CITY OF ALBUQUERQUE

**RE: U-Haul
2217 4TH St. NW
Grading & Drainage Plan
Engineer's Stamp Date: 01/28/20
Hydrology File: H14D110**

Based upon the information provided in your submittal received 03/31/2020, the Grading & Drainage Plan **is not** approved for Building Permit and SO-19 Permit. The following comments need to be addressed for approval of the above referenced project:

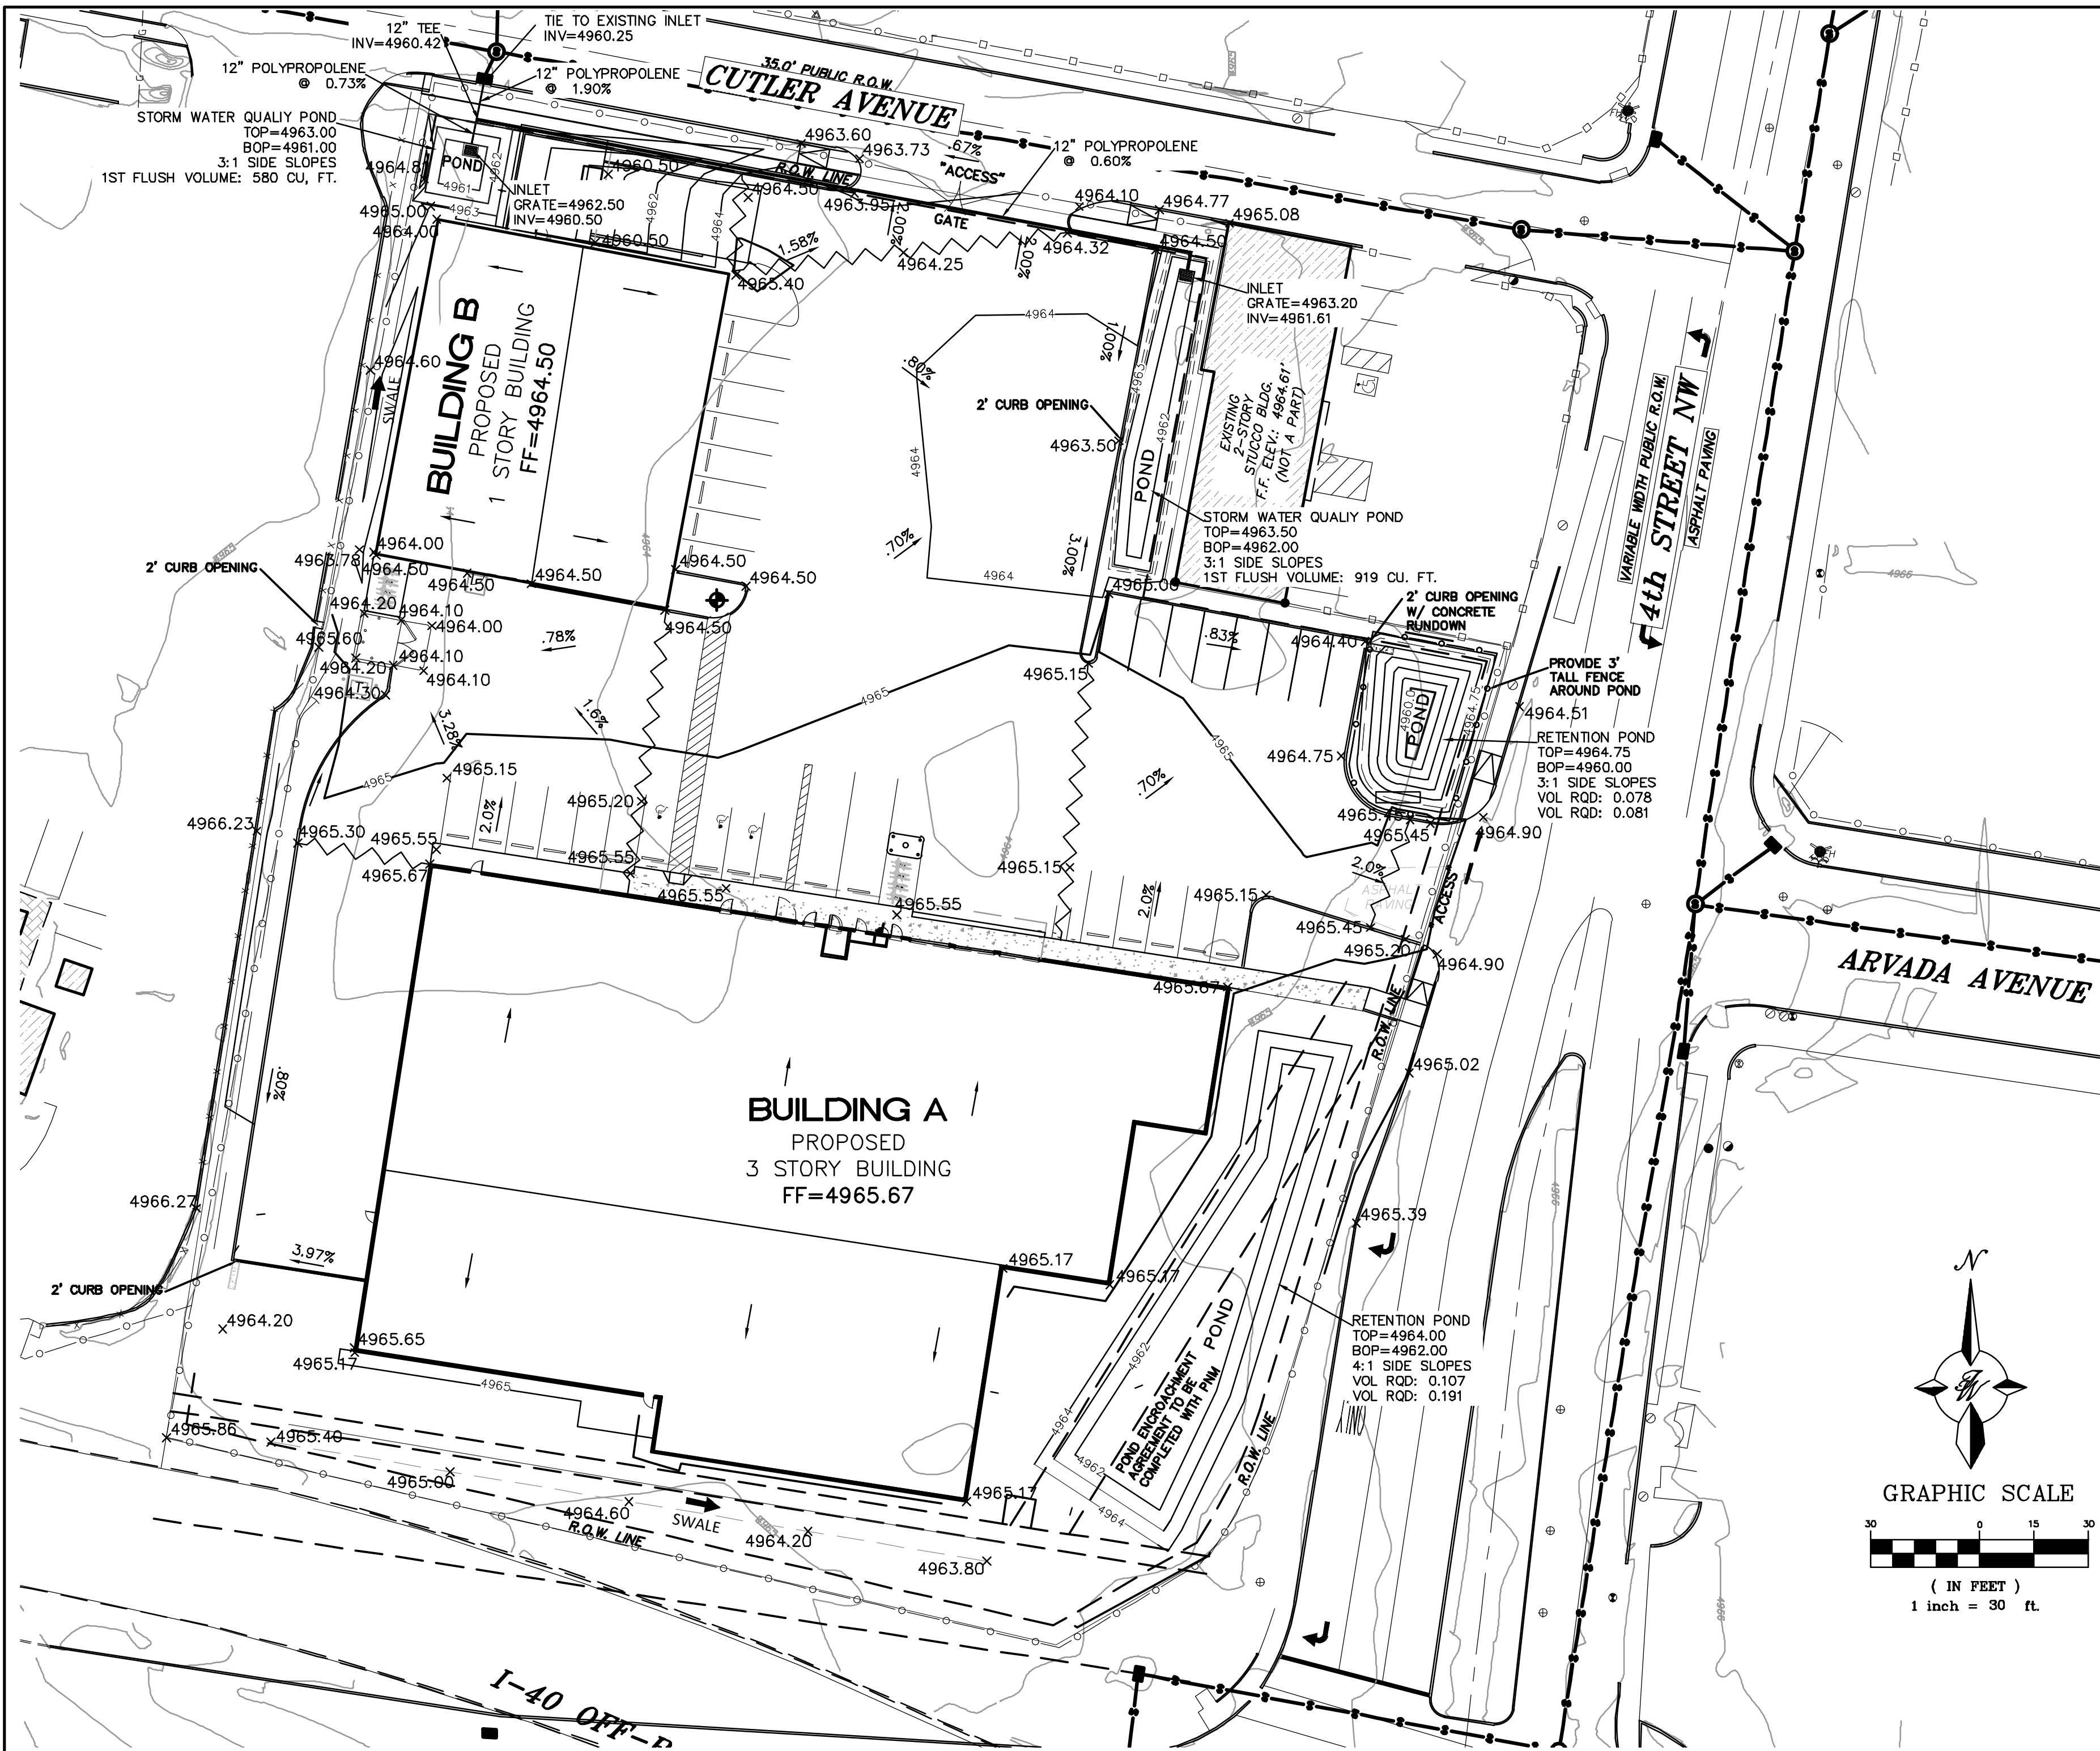
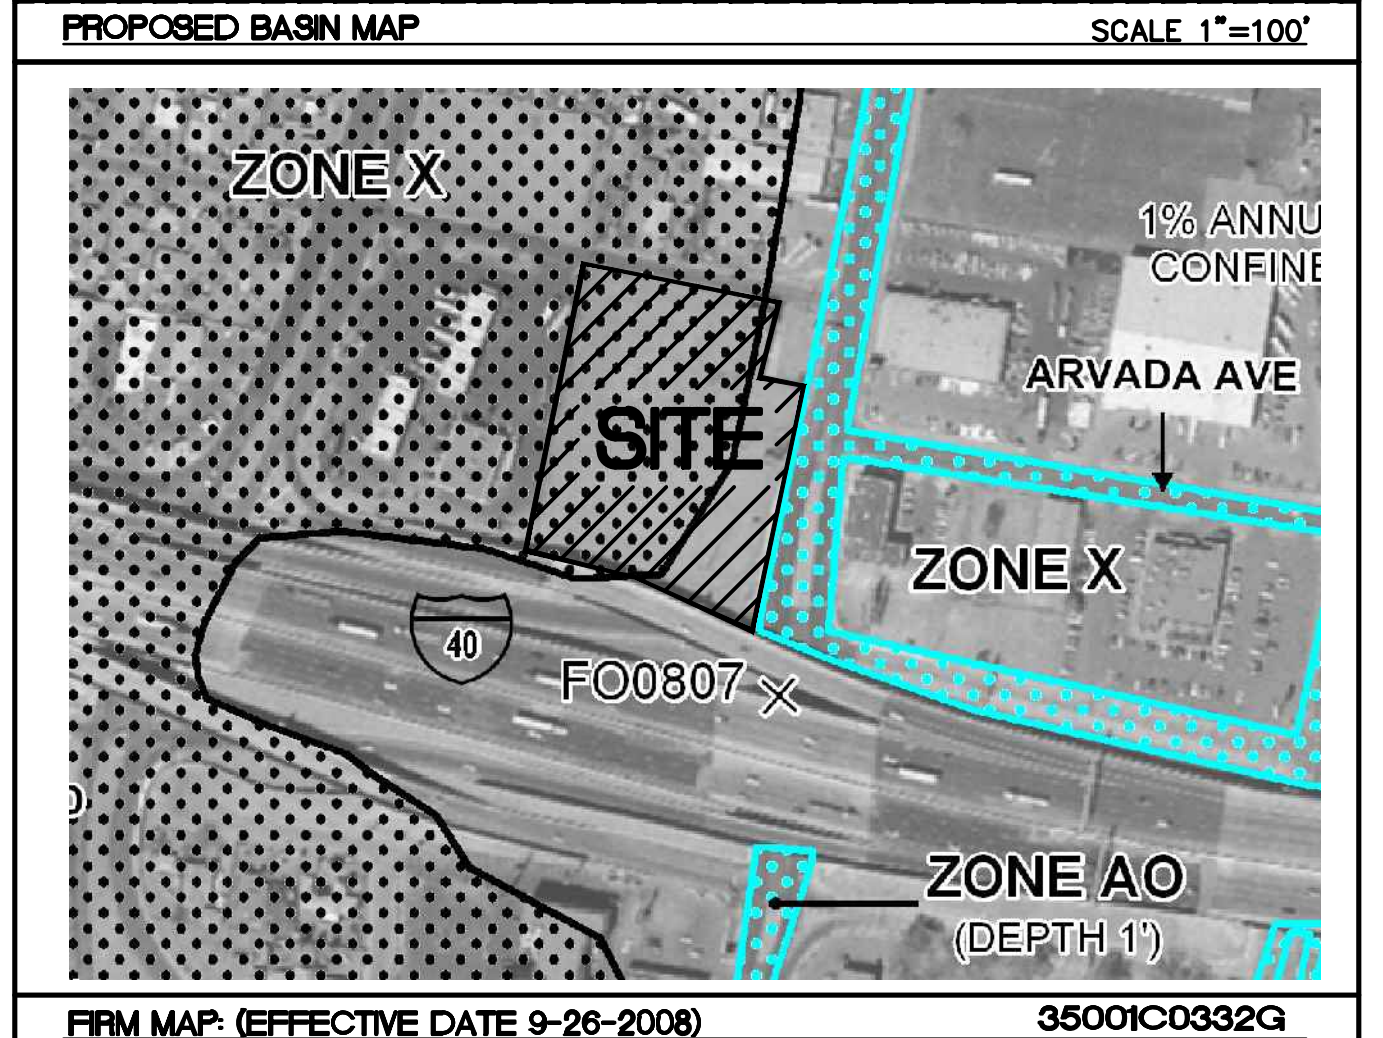
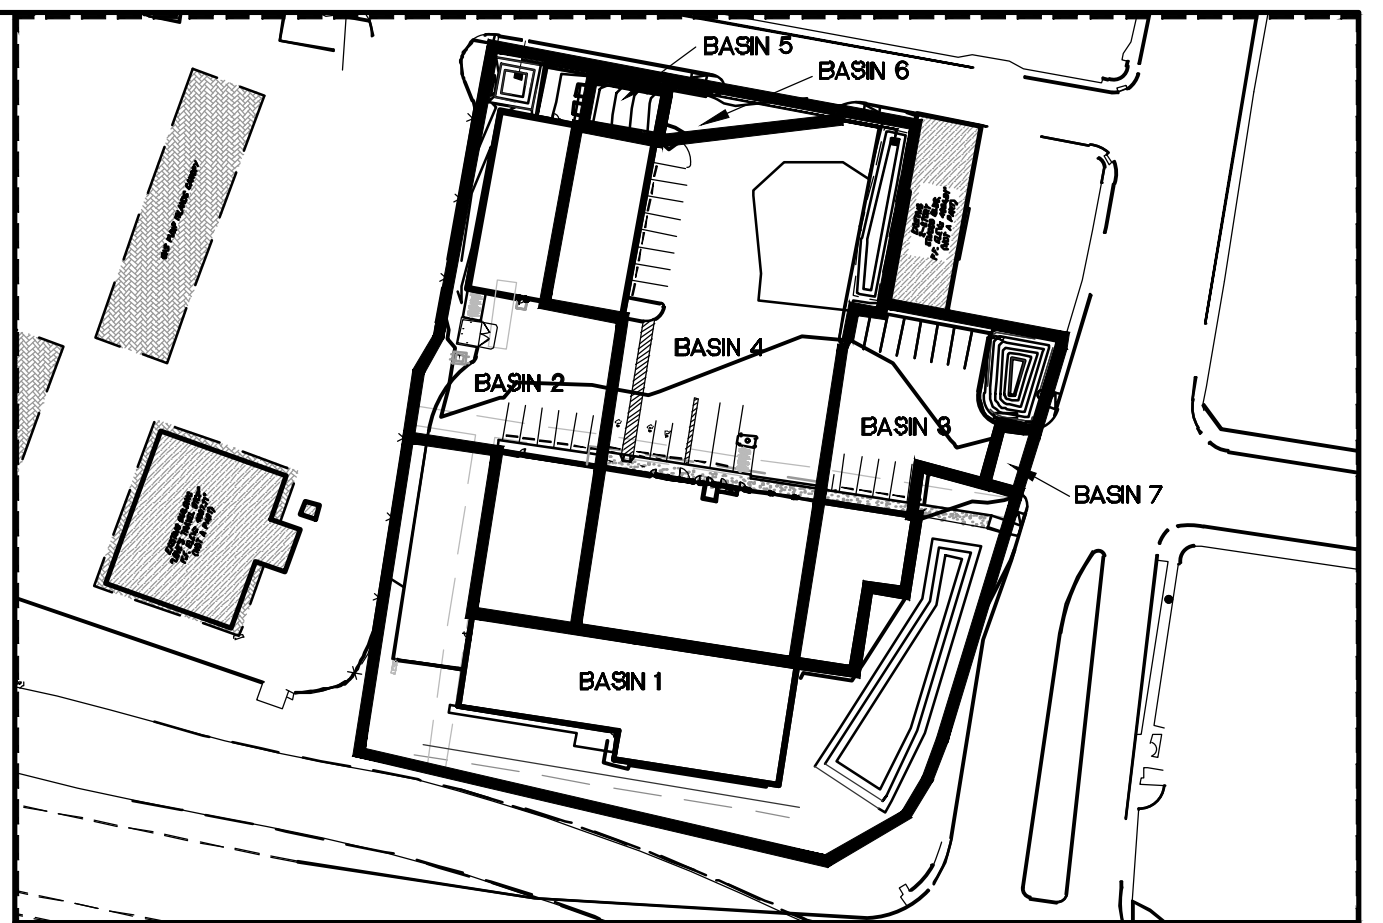
1. Please use the latest SO-19 Notes. See attachment.
2. Please update your use of "First Flush". This is an old 1990s term and please update it with "Stormwater Quality" instead.

3. Please provide an emergency spillway for both retention ponds by way of sidewalk culverts.
4. Please provide a cross section of both retention ponds showing the 100 yr – 10 day volume, top of pond, bottom of pond, and the elevation of the emergency spillway (sidewalk culvert).

5. Please add the broad crest weir equation (equation 6.60 in the DPM) for the 2 ft curb cuts and the sidewalk culverts.. A coefficient of 2.7 is typically used for the equation $Q = CLH^{2/3}$.

6. Please reference City of Albuquerque standard detail No. 2236 – Sidewalk Culvert with Steel Plate Top at the sidewalk culvert.
7. Please update the SO-19 Permit Notes. See Attachment.

8. Please show and label the slump pump along with the force main. Also provide the cut sheet for the pump along with the performance curve.
